Our Reference: SYD17/00943/02 (A1613418)
DP&E Reference: SSD 8614

**SSD8614 – New Hurlstone Agricultural High School
2 College Street Richmond**

Roads and Maritime has reviewed the submitted documentation and provides the following comments for your consideration in the determination of the application:

DRAWING  
**Master Plan - Site**

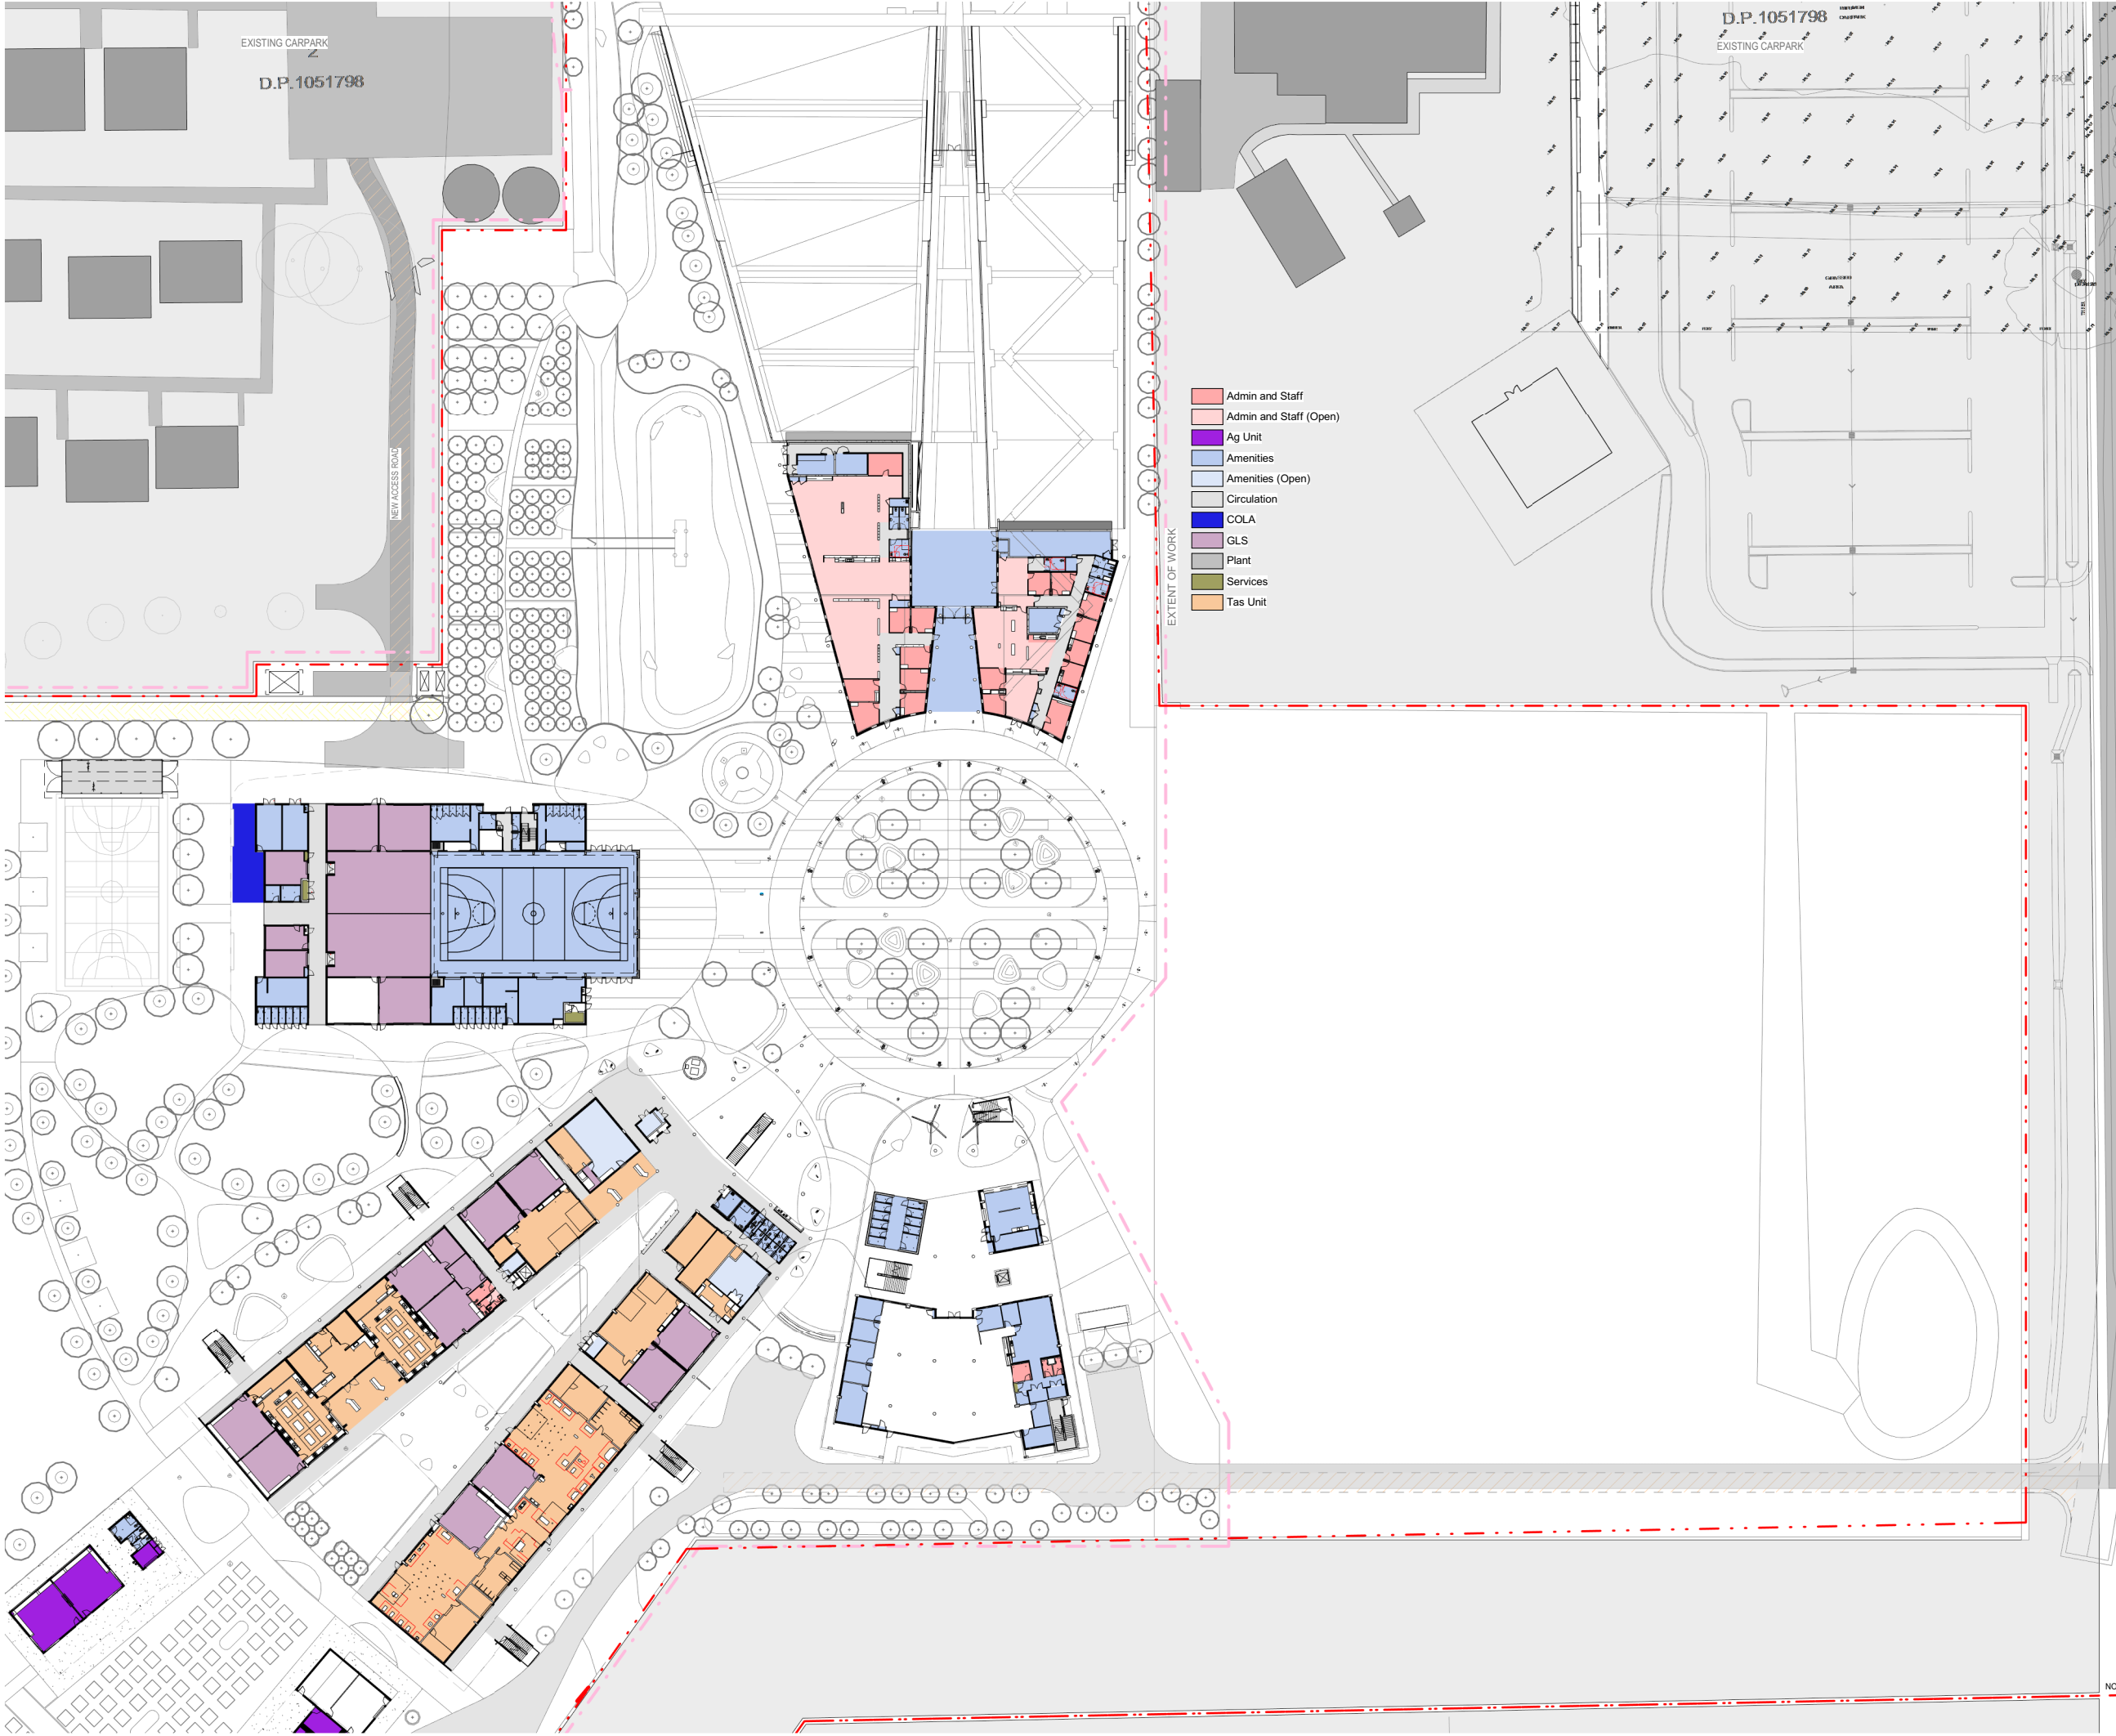
8. The proposed school is located some 600m from the closest State Road (Londonderry Road) the parking arrangements and is unlikely to affect the main road network. However "No Stopping" should be installed along the length of both sides of Vines Drive to ensure the narrow carriageway remains clear for two way traffic, including passing buses. It is understood the school proposes to take the existing parking area known as P47, which is currently dedicated to university patrons, and allocate it to the school parking lot. This will mean university staff and students will be required to find alternate parking.

10. The carpark layout shown in figure 4.1 is not ideal as buses are utilising the same area as the parent car park and the drop off / pick up zone. There needs to be physical separations. Furthermore, the carpark does not meet Council's DCP of 276 spaces.

11. It is noted there will be 70 bicycle spaces allocated and there are no bike paths within the university grounds. Roads and Maritime support Vines Road being widened to allow a

3.5m carriageway in each direction, with appropriate footpaths and crossings implemented in conjunction with a school zone. "No Stopping" should be installed along its length on both sides.
